Application No: FP/136/21/PL
Site Address: Beachcroft Hotel Clyde Road Felpham PO22 7AH
Description of works: Re-modelling of existing swimming pool with re-clad elevations and private roof terrace over. This site is in CIL Zone 4 (Zero Rated) as other development.

Thank you for your internet representation made on 16th July 2021 which has been recorded as an objection with the comments as follows:

Proposed Roof Terrace Plan

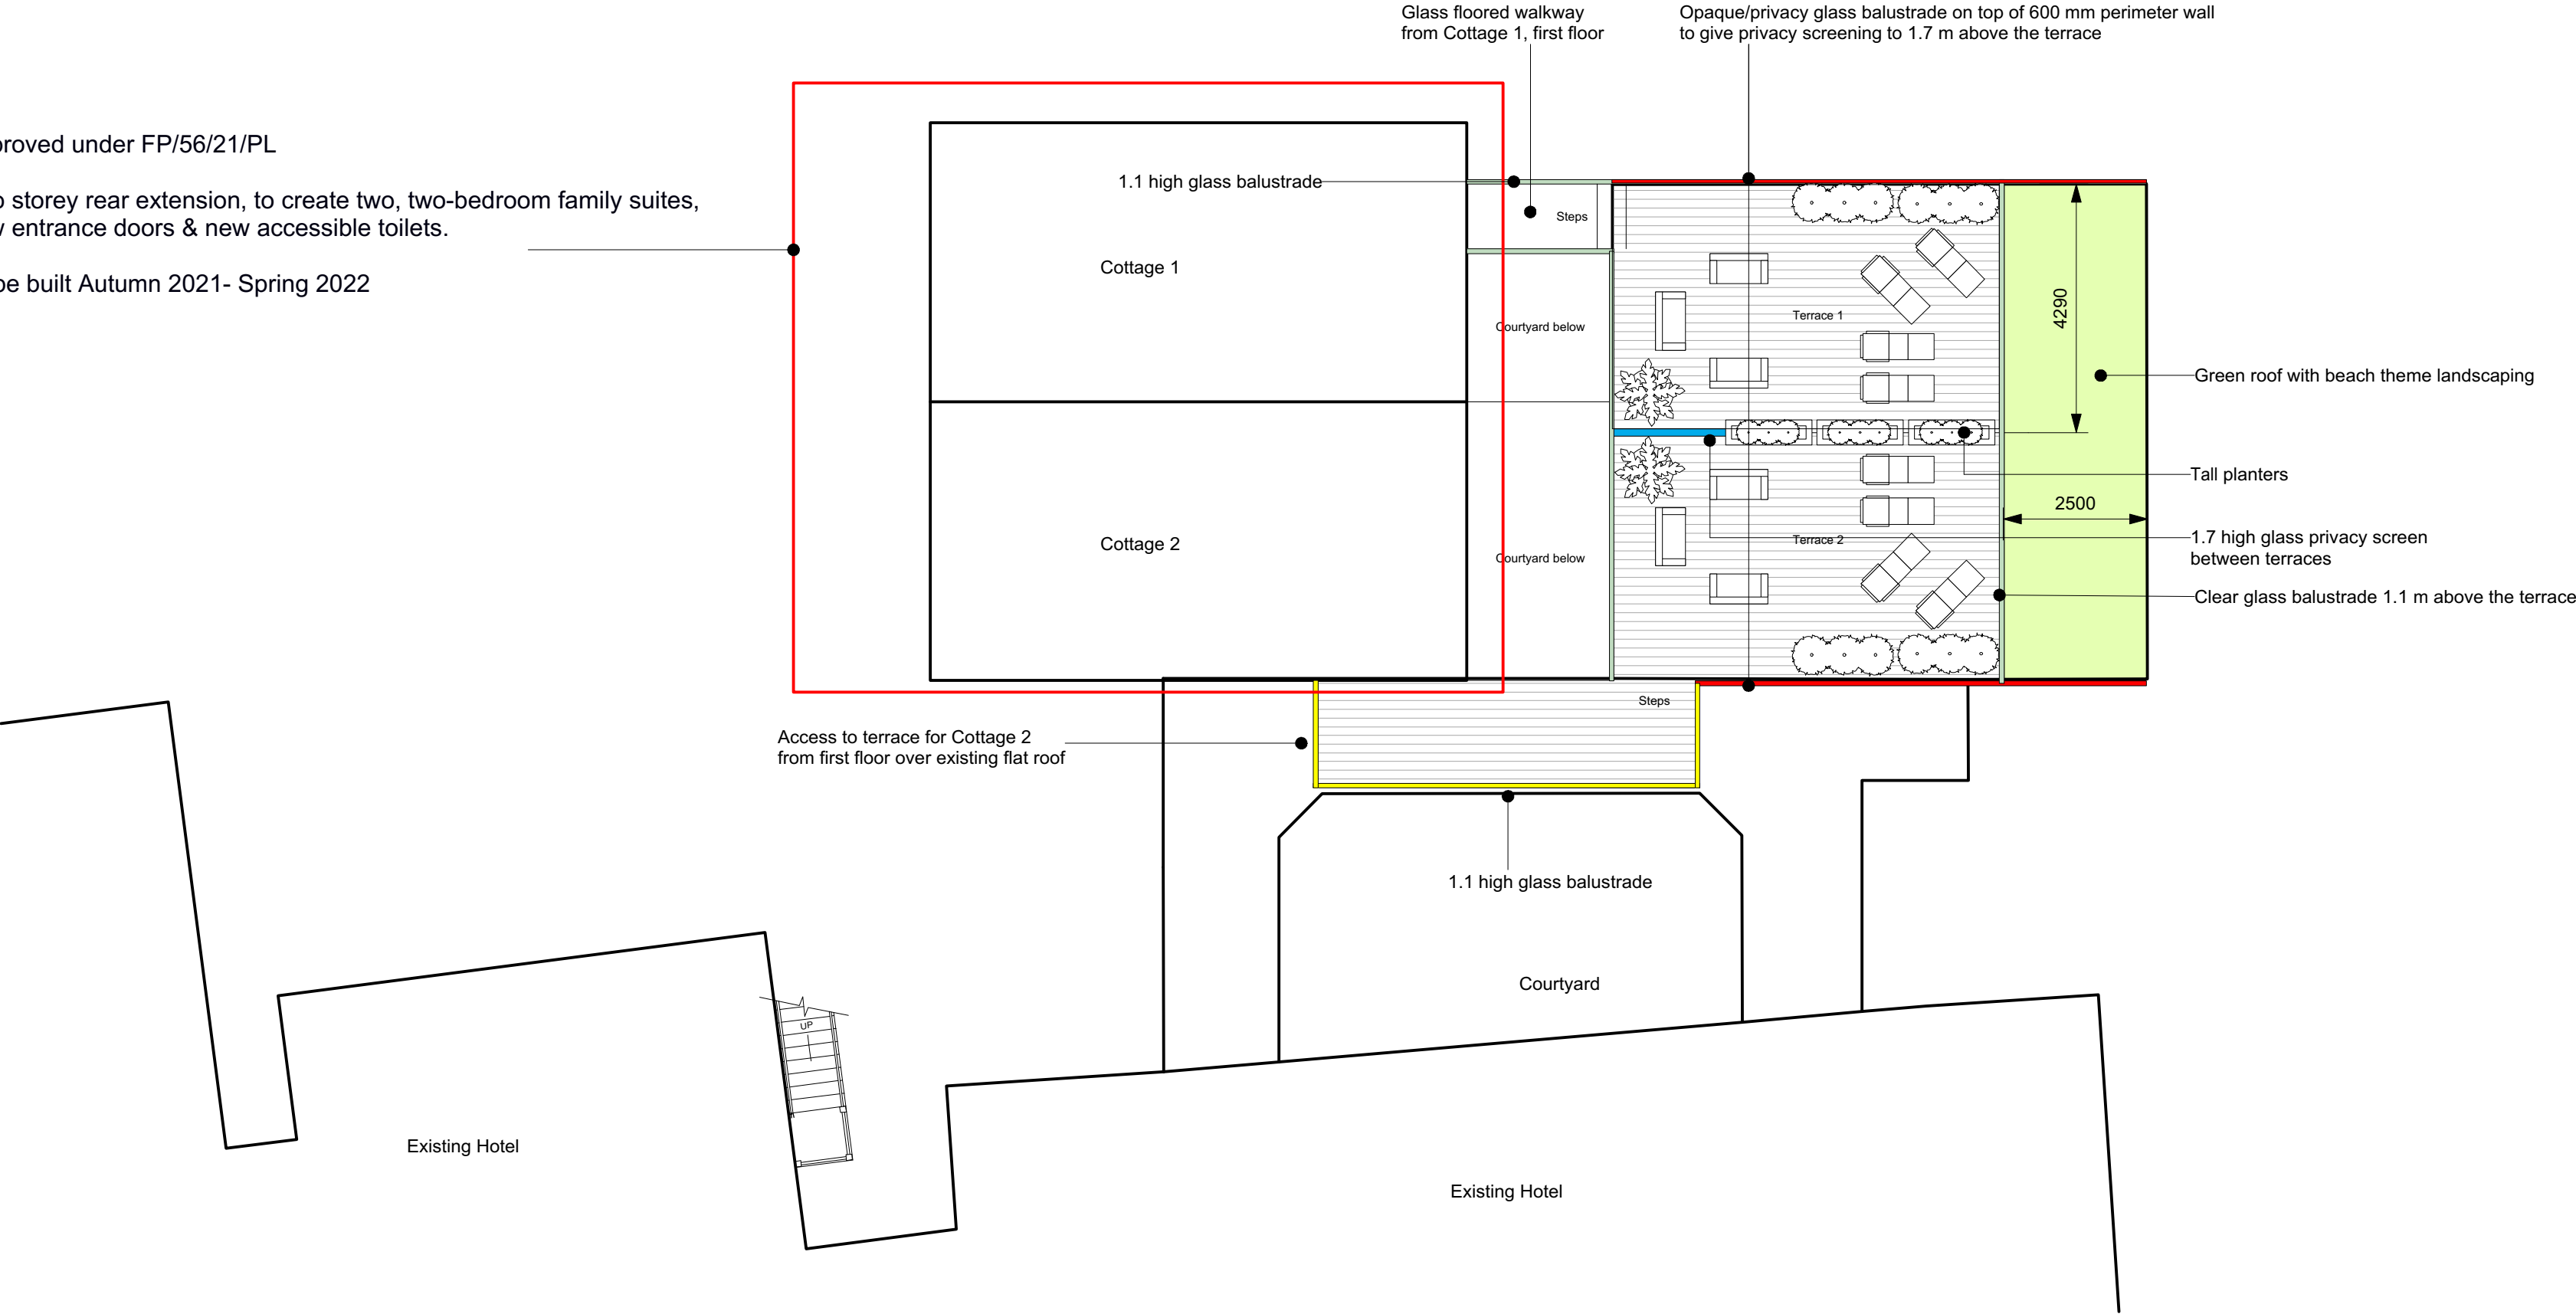
On behalf of Canning Court Management Company Ltd and the 8 lessees of the above property, we strongly object to the proposal of the development by the Beachcroft Hotel's proposed plan to put glass terraces on top of the swimming pool roof.

This proposal would be an intrusion to the privacy of all 8 flats at Canning Court which are situated directly opposite to the proposed development.

The proposal would face Canning Court flats which are parallel to the project. The flats would look directly out on to the terraces and the people on the terraces would have uninterrupted views into the flats. In addition there is potential for excess noise during the day and unsocial hours which would affect the quality of the lives of the flat owners.

We would like to point out that the distance from the proposed terrace to the windows of our flats would only be 14 metres. We believe this would be against planning regulations as it is below 20 metres.

The proposed terraces could also have the potential to be used for functions by other people and non residents and not solely for the use of the cottages, creating the potential for further invasion of privacy and further excess noise at all hours of the day.
